NSW Planning & Environment

I refer to the Department's letter of 24 January 2019 regarding Notification of Modification Request for the Eastern Creek Business Hub Concept Plan, (SSD 5175 MOD 6) at Rooty Hill Road South, Eastern Creek for 'Modification to the concept approval (SSD 5175) to transfer 500m2 of gross floor area (GFA) from large format retail to the child care centre, resulting in a child care centre with a total GFA of 1,200m2 and re-located to the south western corner of Lot 2'. Submissions need to be made to the Department by 8 February 2019.

Figure 4 | Approved concept plan (left) and proposed (right) concept plan (Source: Applicant's SEE)

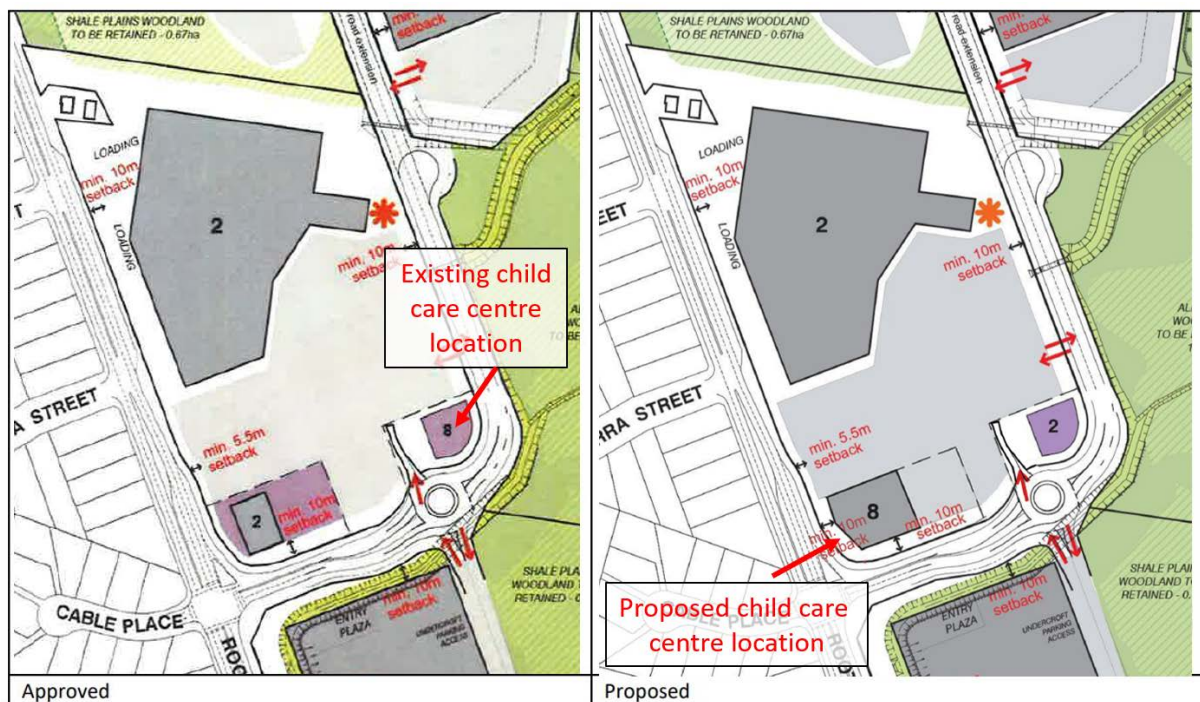
As shown in the below site plan from Endeavour Energy's G/Net master facility model (and extract from Google Maps Street View) in regards to the proposed child care centre site there are:

- No easements benefitting Endeavour Energy (active easements are indicated by red hatching).
- Low voltage and 11,000 volt / 11 kilovolt (kV) high voltage overhead power lines to the opposite side of Rooty Hill Road South.
- Low voltage overhead power lines crossing Rooty Hill Road South to a streetlight located in proximity of the site.

If the child care centre is in proximity of a padmount substation, the applicant should check with the proponent and their ASP responsible for the network connection to the site that any padmount substation earthing has been designed to comply with the 'special location' requirements under EDI 100 ie. at the time the ASP did the design they may not have been aware of the intended use of part of the site as a child care centre.

Should such a development proceed, the design of the child care centre should also consider prudent avoidance measures such as any rooms which the children will occupy (play areas, sleeping rooms, eating areas) be arranged such that they are on the side of the site/building which is furthest away from the electricity infrastructure.
